17 June 2022
Our Ref: 21007D.6NB (S4.55(2))

**RE: SECTION 4.55(2) APPLICATION TO MODIFY
DEVELOPMENT CONSENT SSD-11920082
HASTINGS SECONDARY COLLEGE – PORT MACQUARIE CAMPUS
16 OWEN STREET, PORT MAQUARIE**

DFP has been commissioned by School Infrastructure NSW (SINSW) to prepare an application under section 4.55(2) of the *Environmental Planning and Assessment Act 1979* (EP&A Act) to modify development consent No. SSD 11920082 (as modified). The modifications include:

project code sheet no. revision  
**HSPM SSDA-120010 05**

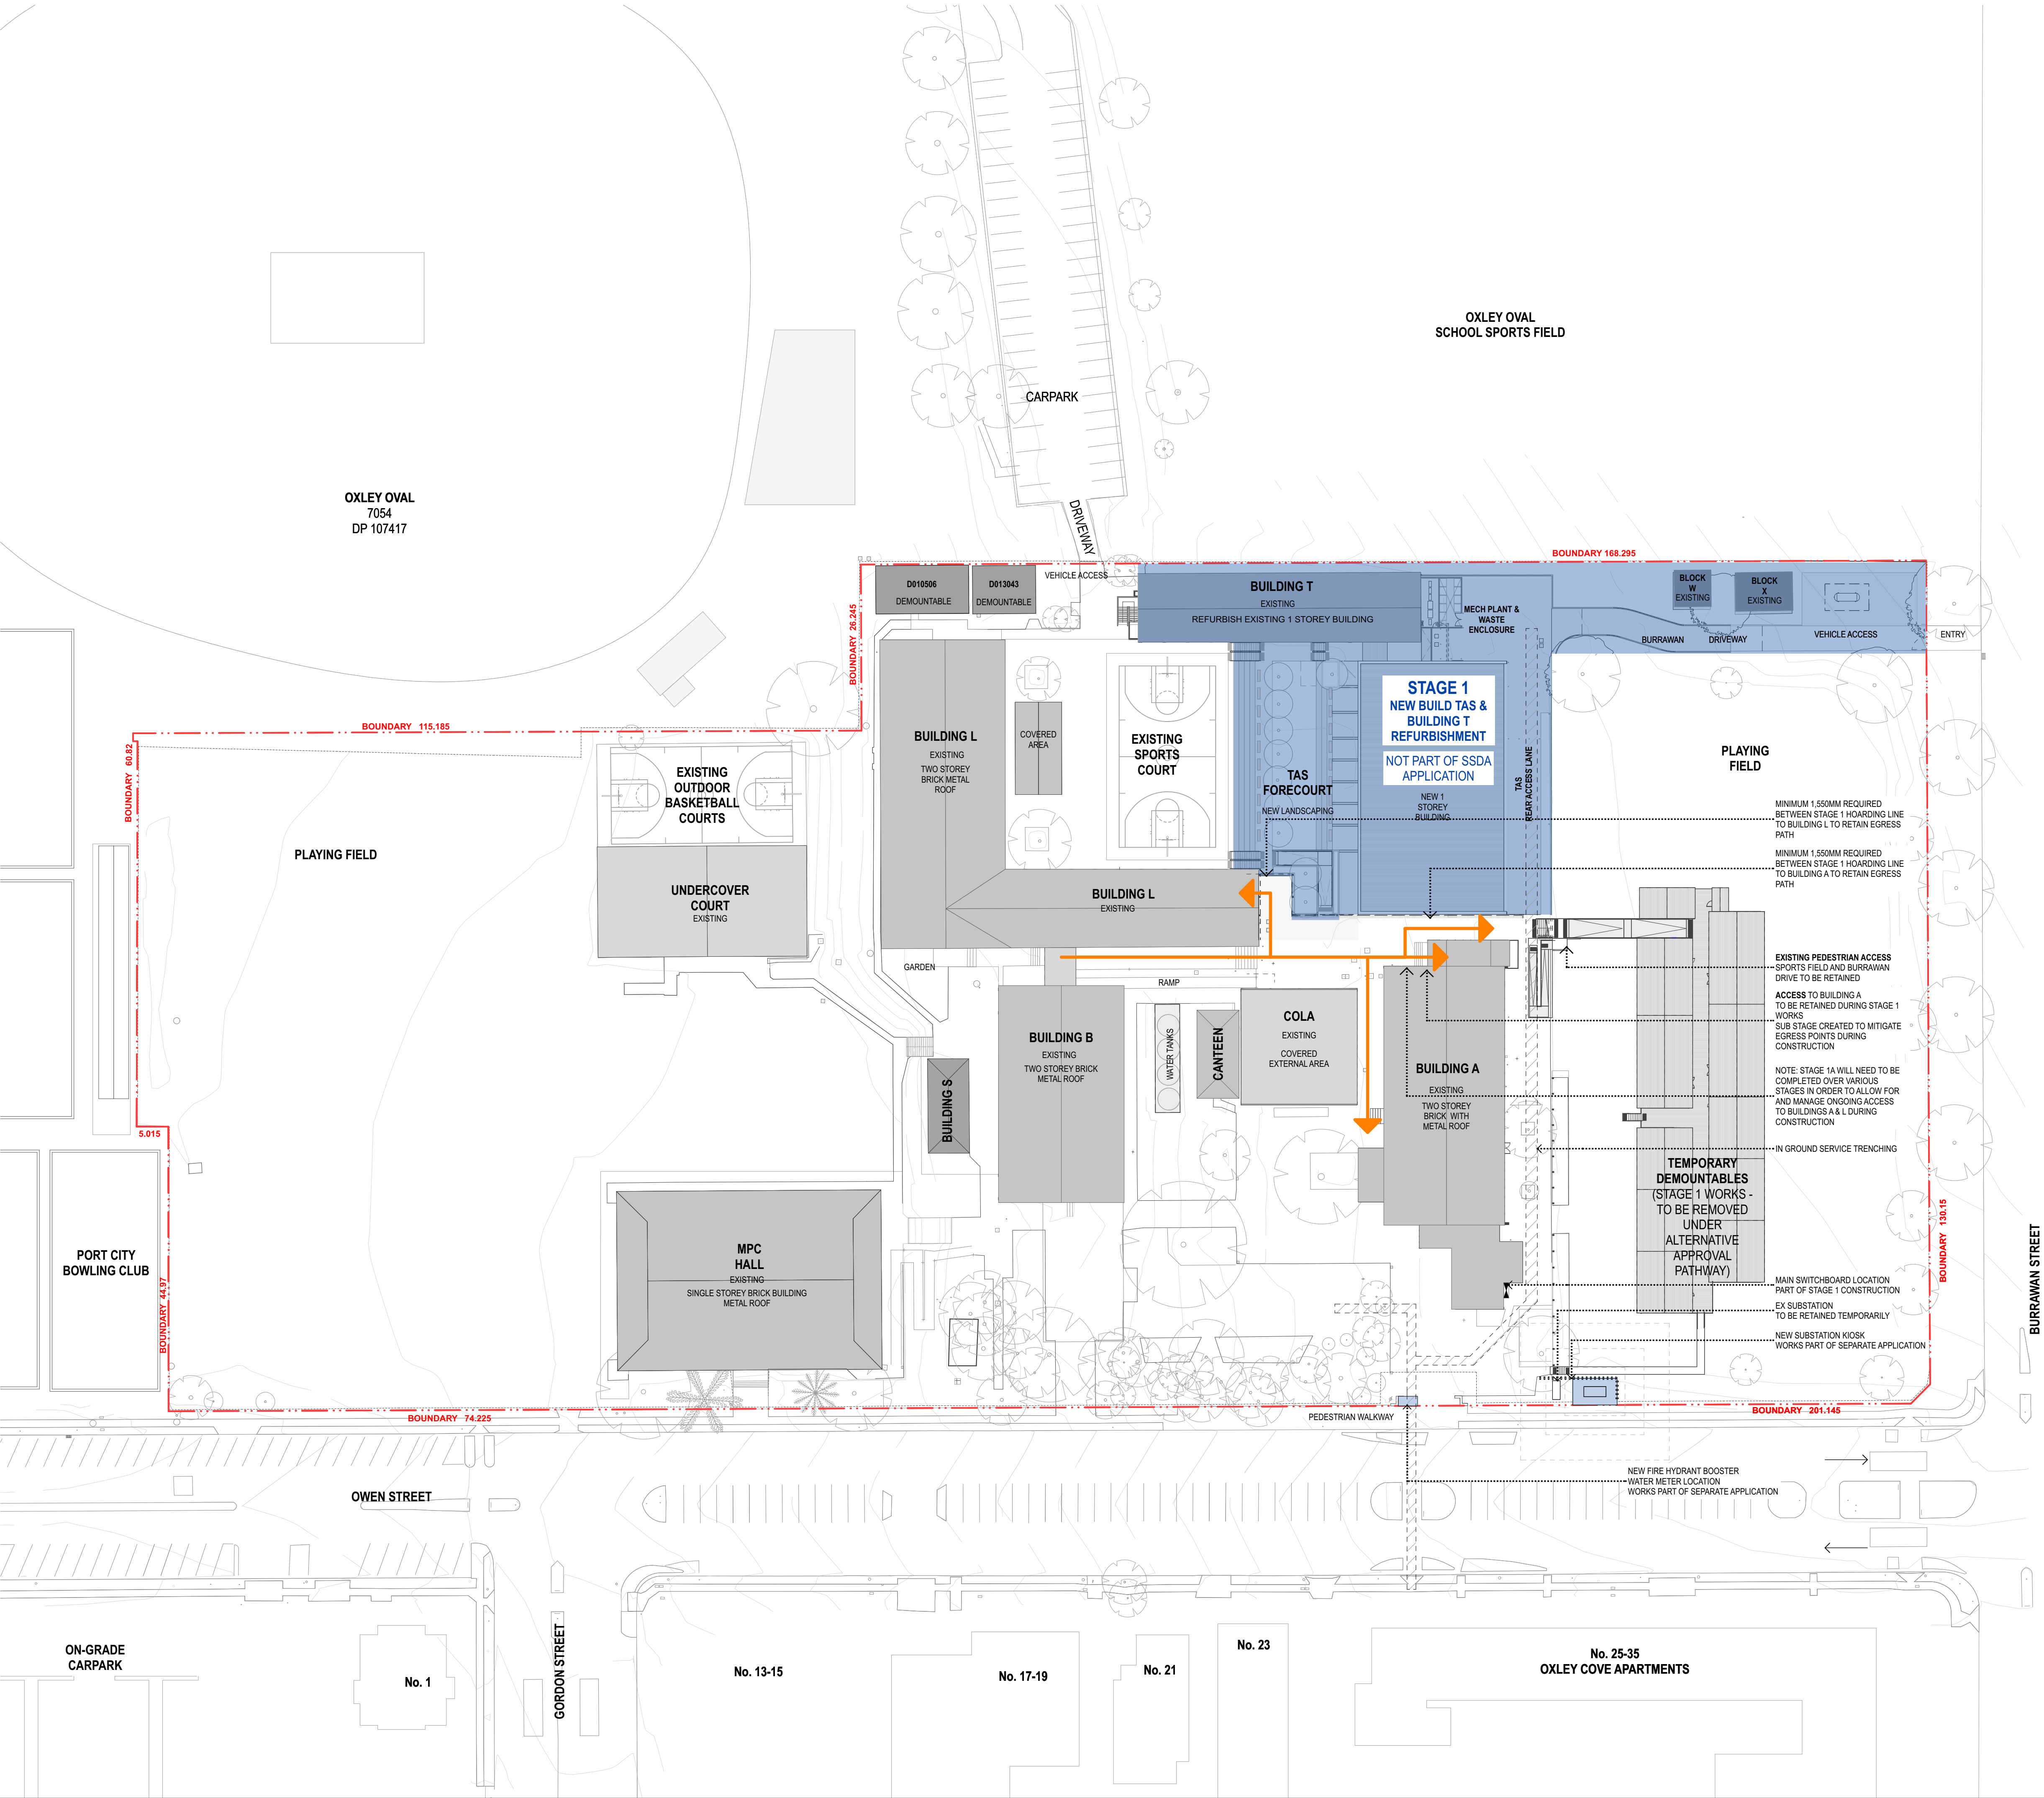
- Amendment of stair locations to avoid existing services;
- Removal of works to Building L;
- Installation of mechanical plant on canopy roof, east of CAPA building;
- Installation of external stairs to CAPA building;
- Reconfiguration of Building A entry, including reconfiguration of undercover walkway;
- Reconfiguration of landscaping at entrance;
- Addition of landscaping to north of Building B and north of PCYC;
- Alteration of scope of works to Building B;
- Change in materials;
- Change to window placement and louvers on CAPA building;
- Minor internal modifications

02 ELEVATION North Elevation (L & CAPA)  
1:200

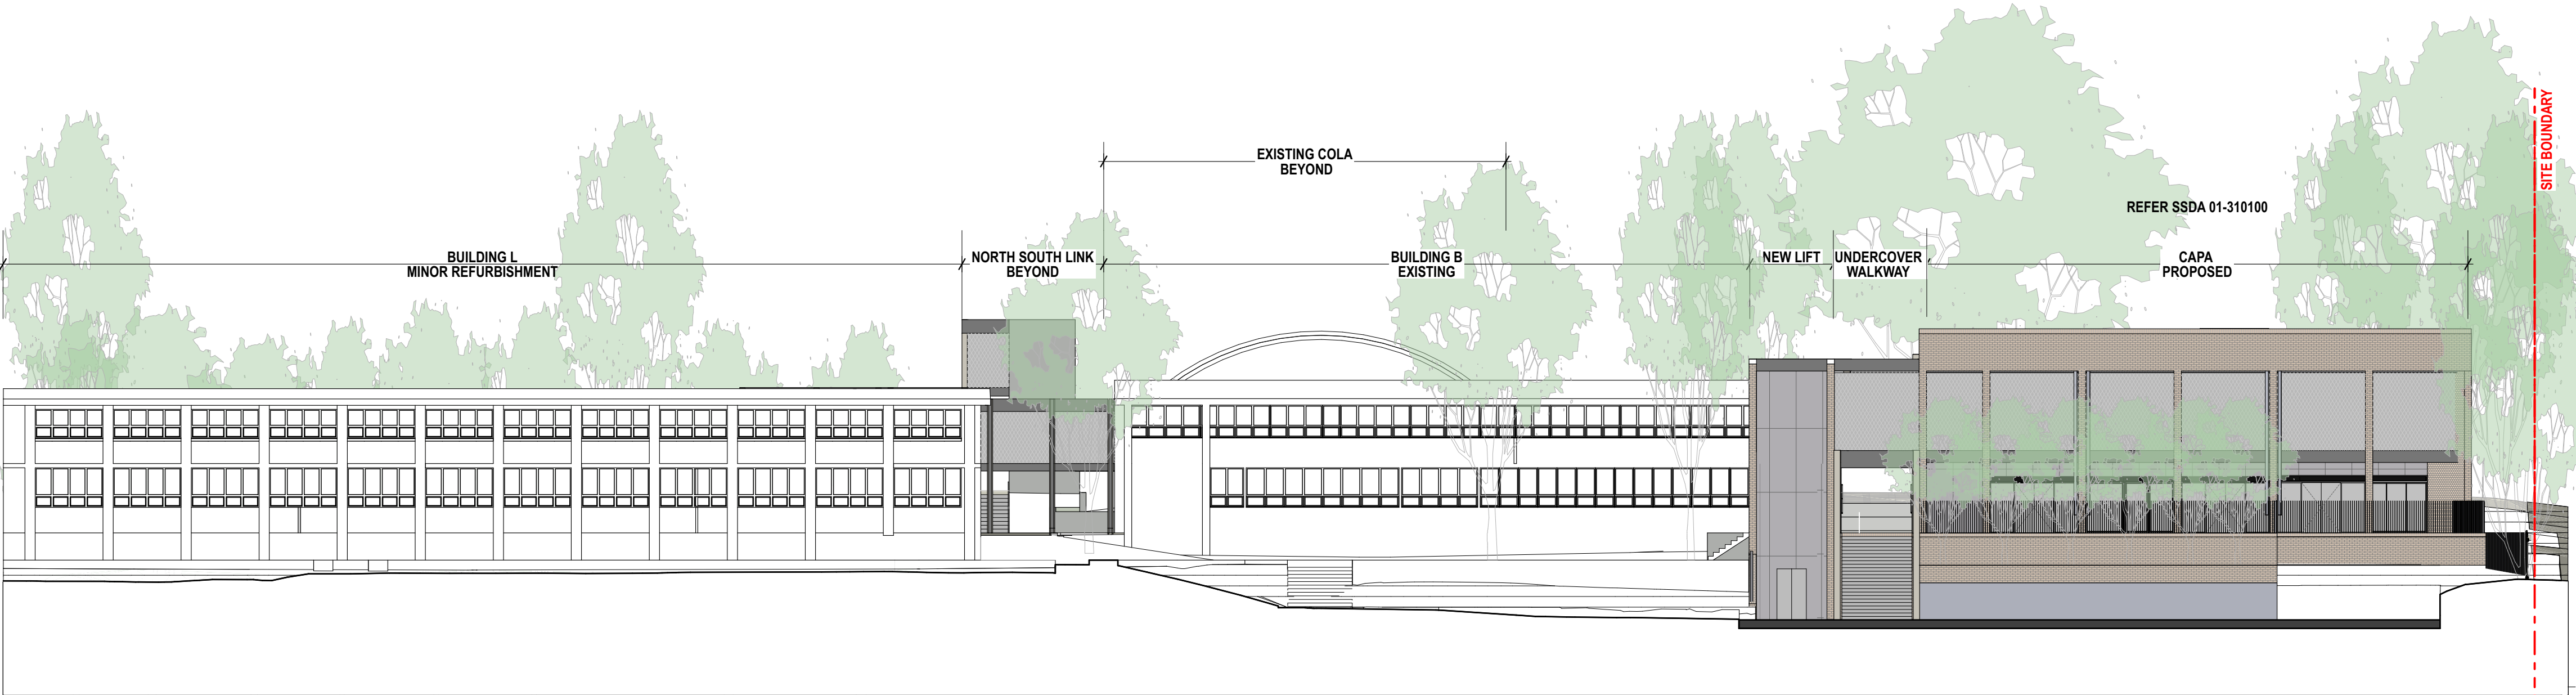
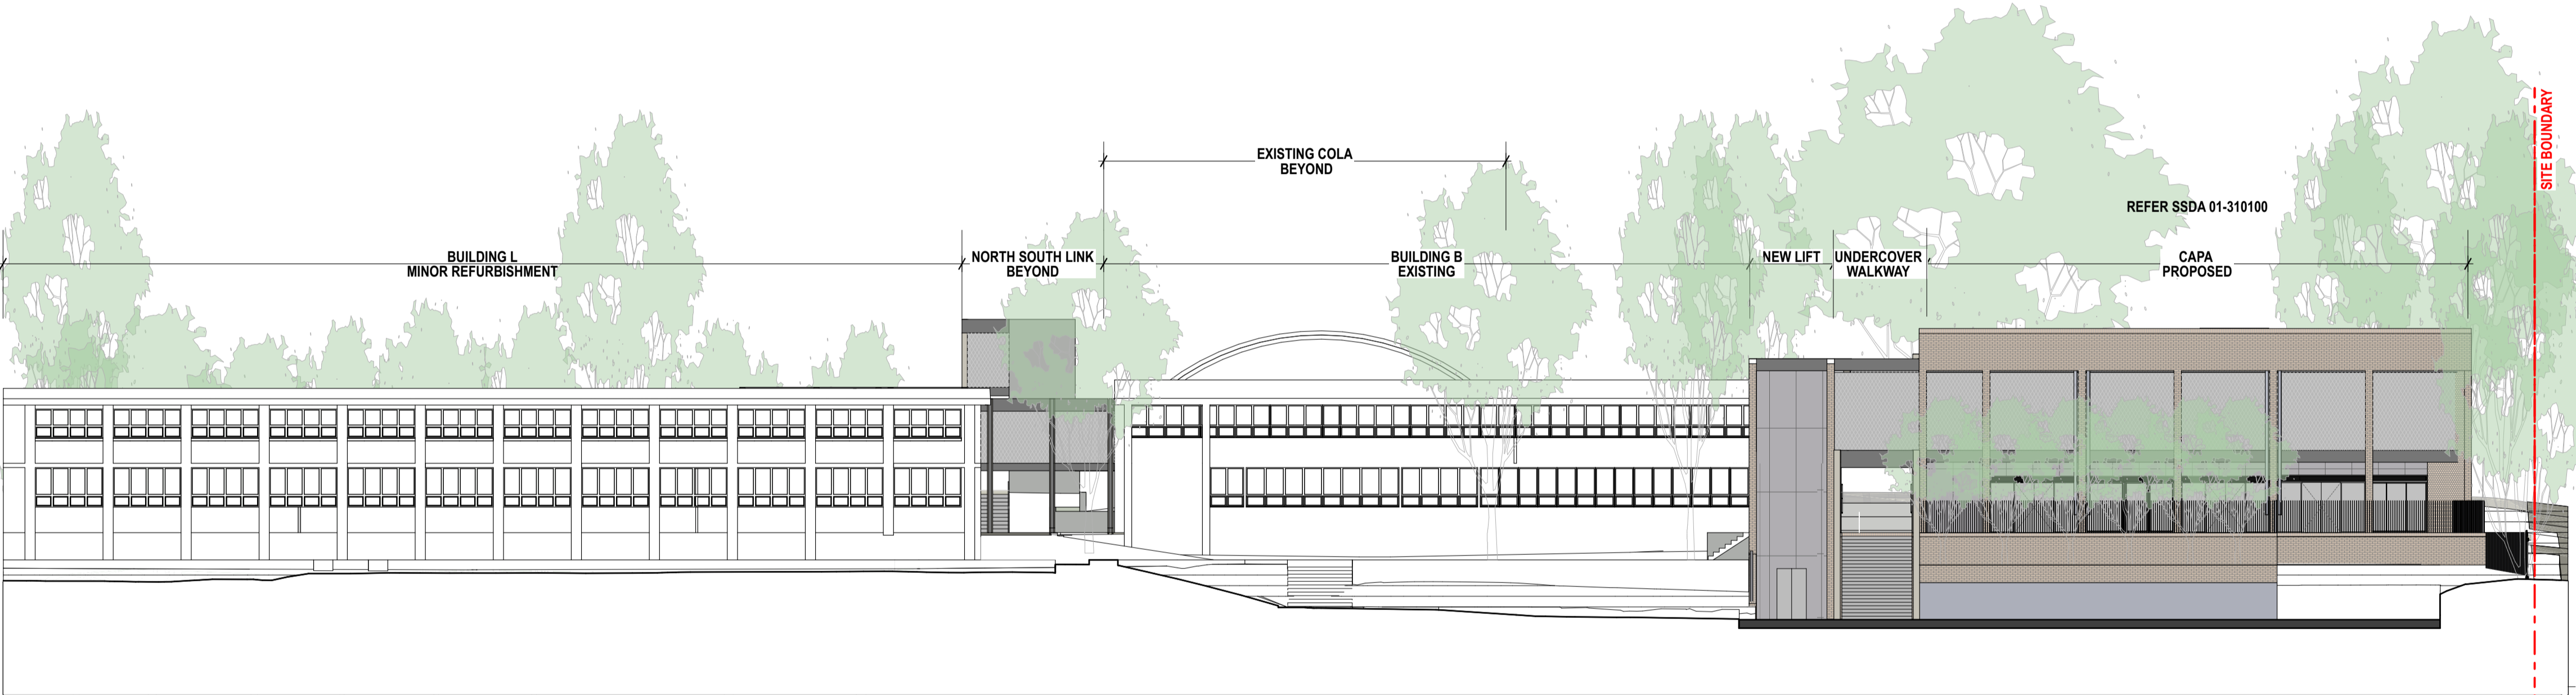
The proposed external alterations will alter the Owen Street streetscape through the addition of mechanical plant, external stairs and a reconfiguration of the entrance to Building A and the associated undercover canopy area. Overall, the modifications have minimal visual or height impact to the streetscape when compared to the approved design. The approved height of the development is 13.88m. The height of the CAPA with the mechanical plant is 11.96m. **Figures 2 and 3** are comparisons of the Owen Street elevation with **Figure 2** being the approved elevation and **Figure 3** incorporating the proposed modifications.
